Subject: NSW Planning & Environment Development Application SSD 8596 Arts and Social Sciences Building, University of Wollongong 2 Northfields Avenue, Keiraville

I refer to the Department's letter of 13 November 2017 regarding Development Application SSD 8596 at University of Wollongong, 2 Northfields Avenue, Keiraville (Lot 1 DP 1188267) for 'Construction of a new four storey Arts and Social Sciences Building on the western side of the campus and associated landscaping and public domain works'. Submissions need to be made to the Department by 15 December 2017. I apologise for the late submission but trust that Endeavour Energy's recommendations and comments will still be considered.

Figure 1 - Existing Endeavour Energy HV

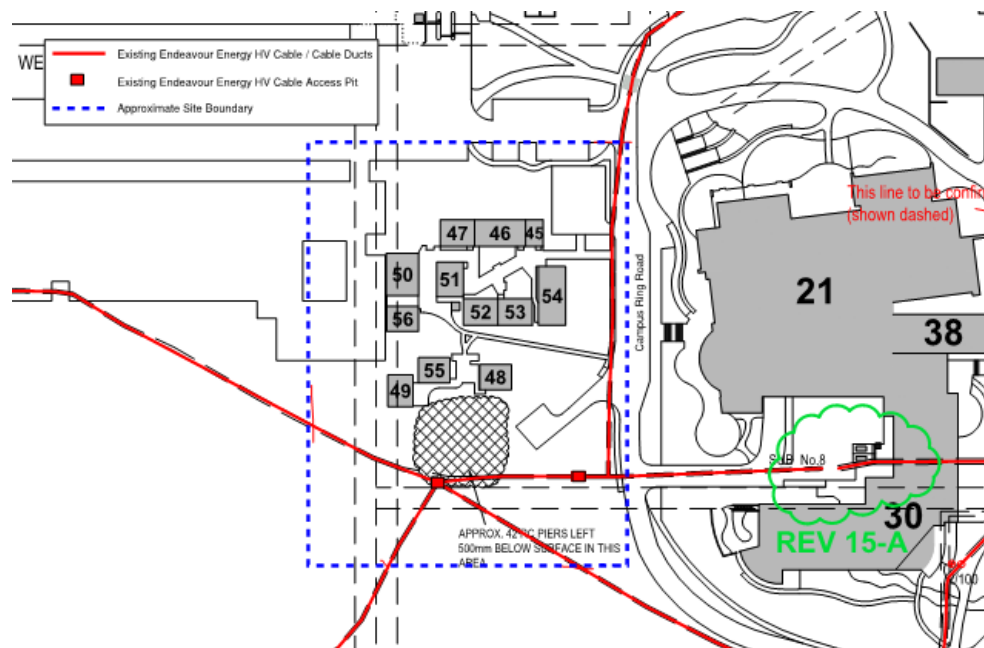
Endeavour Energy has noted that from the Electrical Services Report it appears that at some time the demountable buildings may have been located over the easement for the underground cables?

It seems that the location of the existing HV cables routing within below ground ducts across the site are mainly through proposed soft landscaping areas. The HV cable routing North-South is within close proximity to the edge of the planned new building, however this looks to be within the proposed paved area and may not be affected. The locations provided are indicative only and a survey will be required to confirm this.

Therefore, it is not anticipated that these existing services will be affected by these works. Careful coordination of any new electrical services within the landscaping area will be considered as the design develops.

Endeavour Energy's preference is for no activities or encroachments to occur within its easement areas. If the proposed works (other than those approved / certified by Endeavour Energy's Network Connections Branch as part of an enquiry / application for load – please refer to the point below 'Network Capacity / Connection') will encroach/affect Endeavour Energy's easements, contact must first be made with the Endeavour Energy's Easements Officer,
